From: Roger Spencer
Sent: 18 April 2017 16:58
To: Planning.Responses
Subject: Planning Application Ref: FG/198/16/PL

APPLICATION NO: FG/198/16/PL

Description of Works: Demolition of existing house with erection of 2 storey building comprising of 8No. residential 2 bedroom flats & associated external works

I am able to inform you that I have received an amendment to the above application dated 10th April 2017 relating to:- Substitute plans 16/046 - PL04 Rev H, PL02 Rev F, PL03 Rev F and PL05 F

BASEMENT FLOOR PLAN

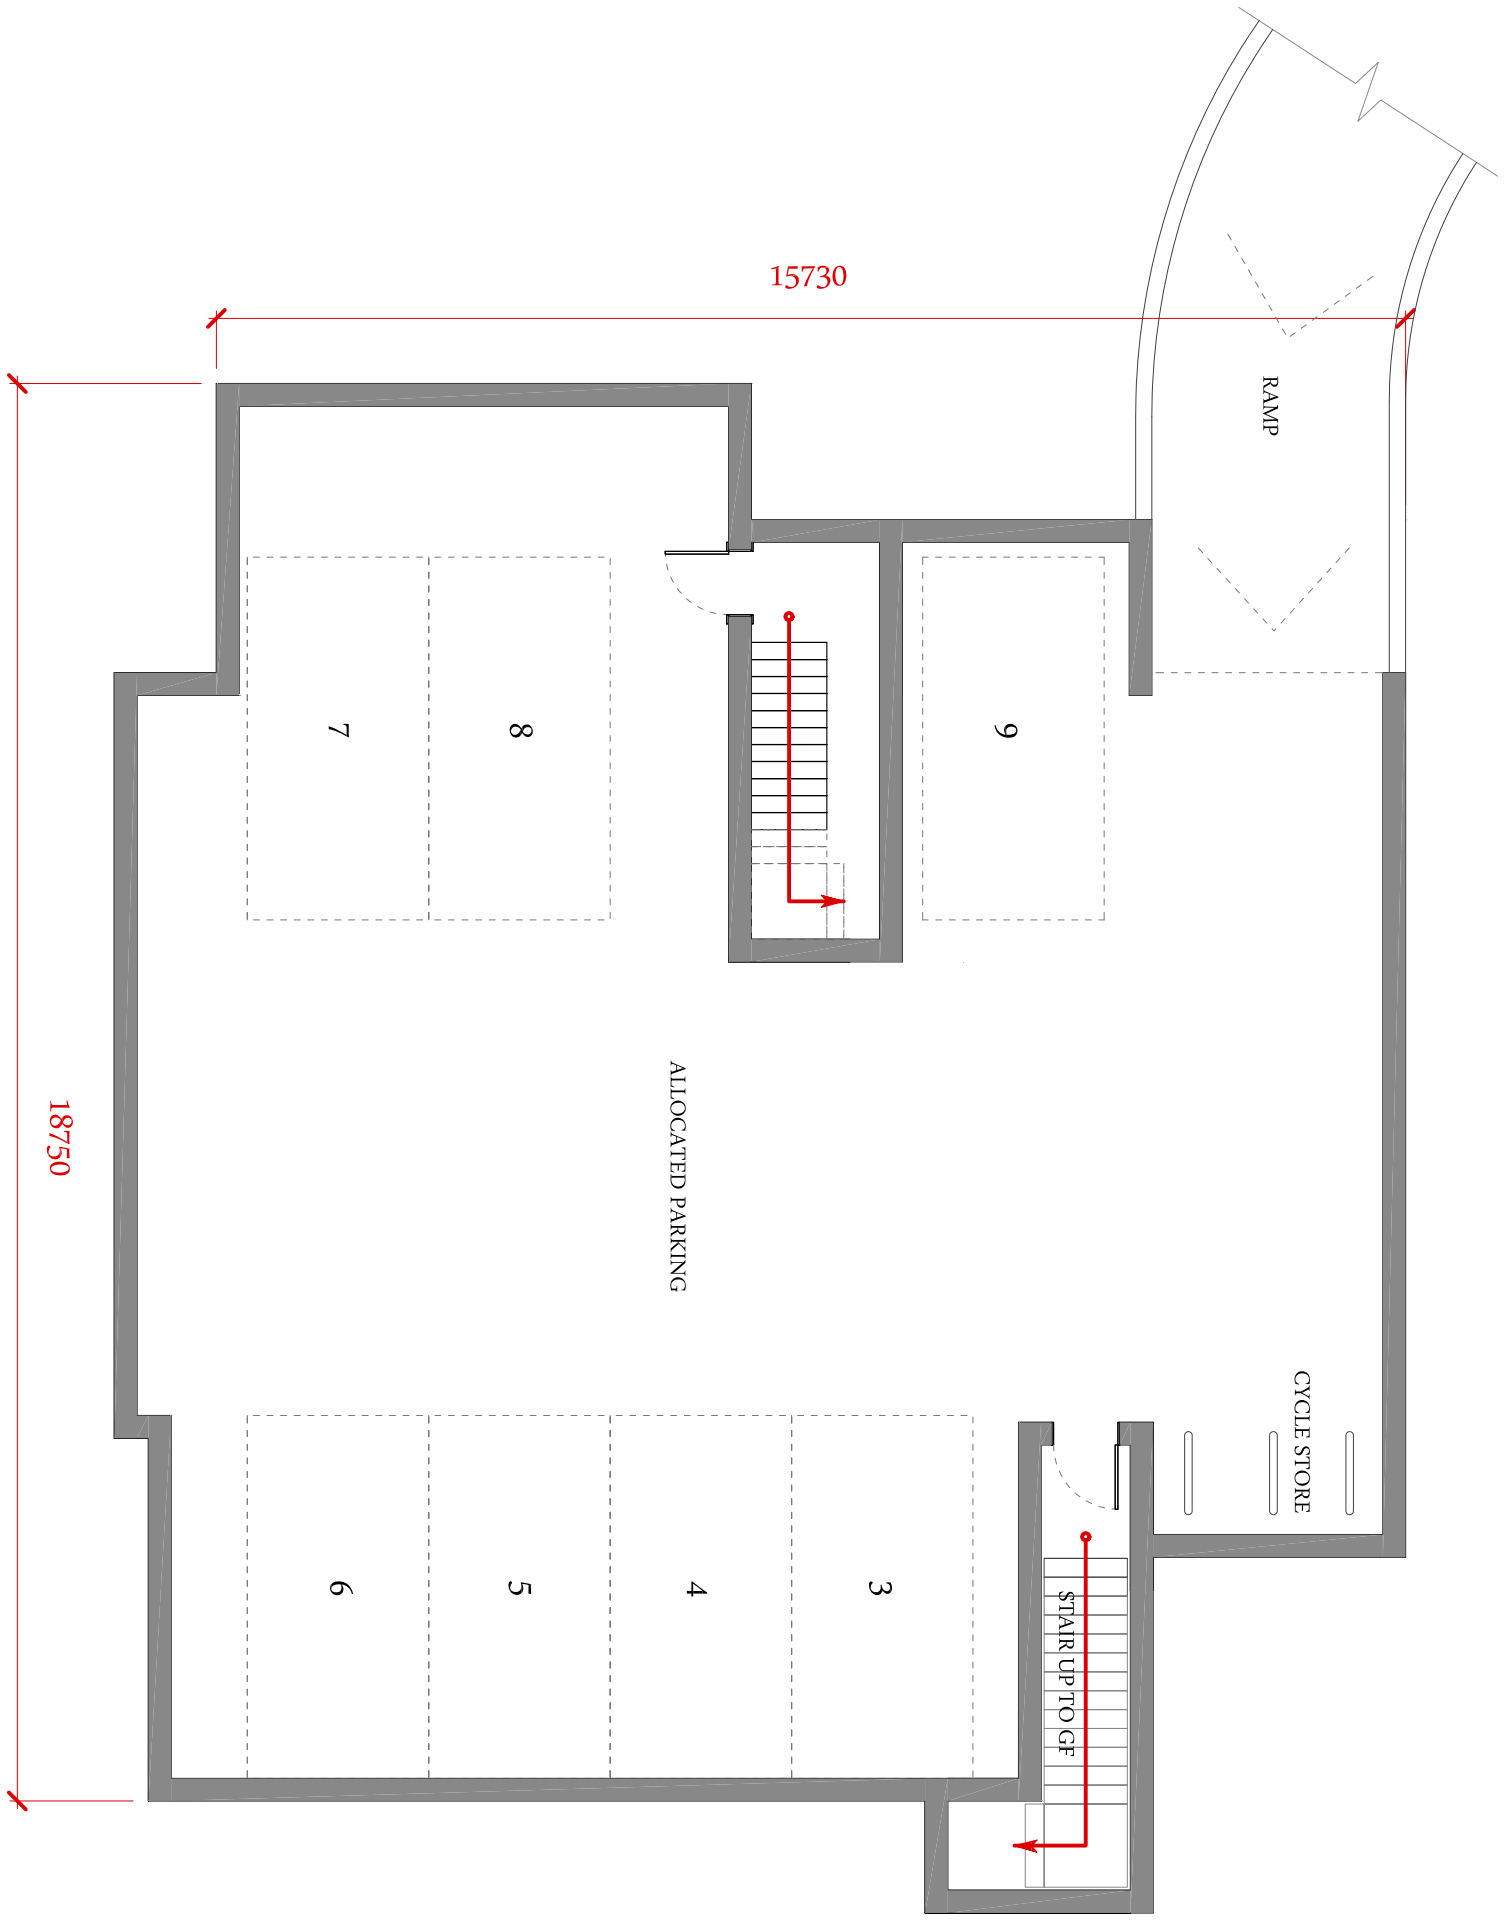
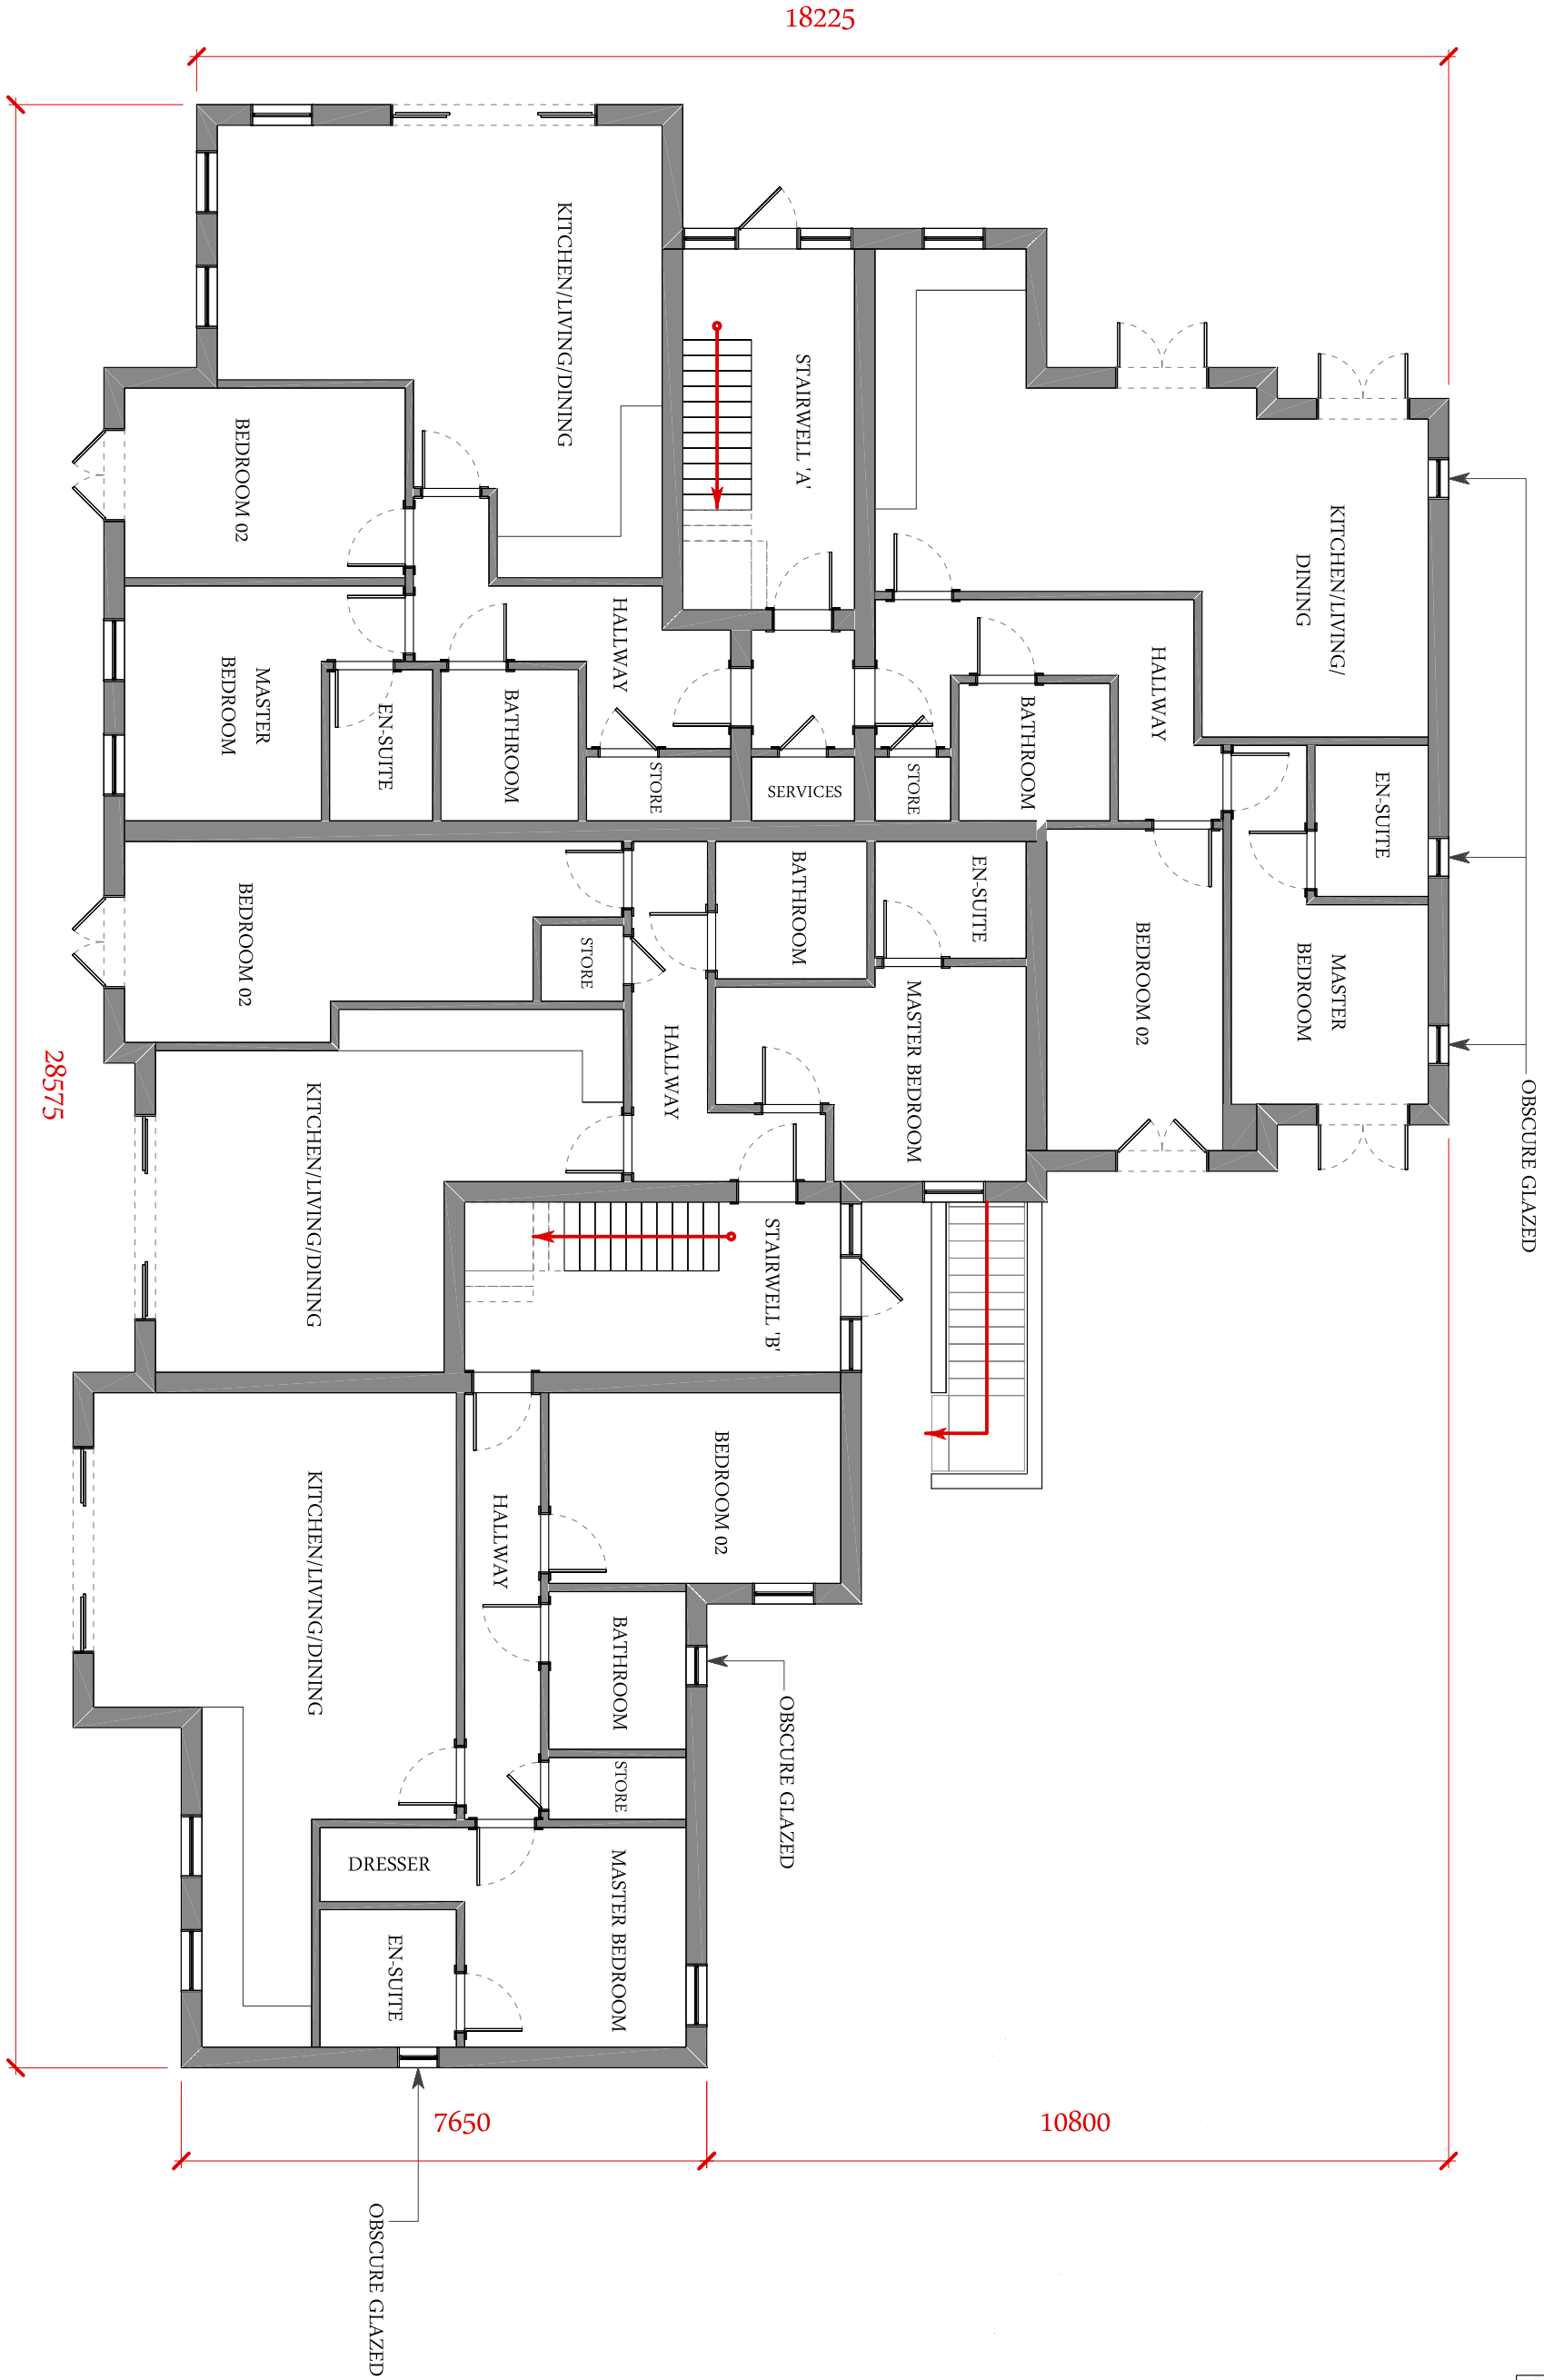
In light of the above, I have no objection to the provision of a parking basement. However that basement could potentially flood in an extreme event. The boundary is to be provided with a rendered wall over the most part (this should be to the same level if not greater than the floor level) but the accesses will become the weak link.

I would suggest therefore that the pedestrian path and vehicular access are both provided with a ‘cill’ level equivalent to the (conditioned) floor levels – this could be by building up the access (providing a continuous seal is provided with the boundary walls) or, as the increase in height may make the ramp into the basement too steep, by the provision of a temporary barrier/gate on the boundary – again continuous with the boundary walls, that could be closed in time of

need. There would be a need also to prevent water entering the site (basement) through the hedging between the site and the neighbouring property (No. 3 Sea Dr.)
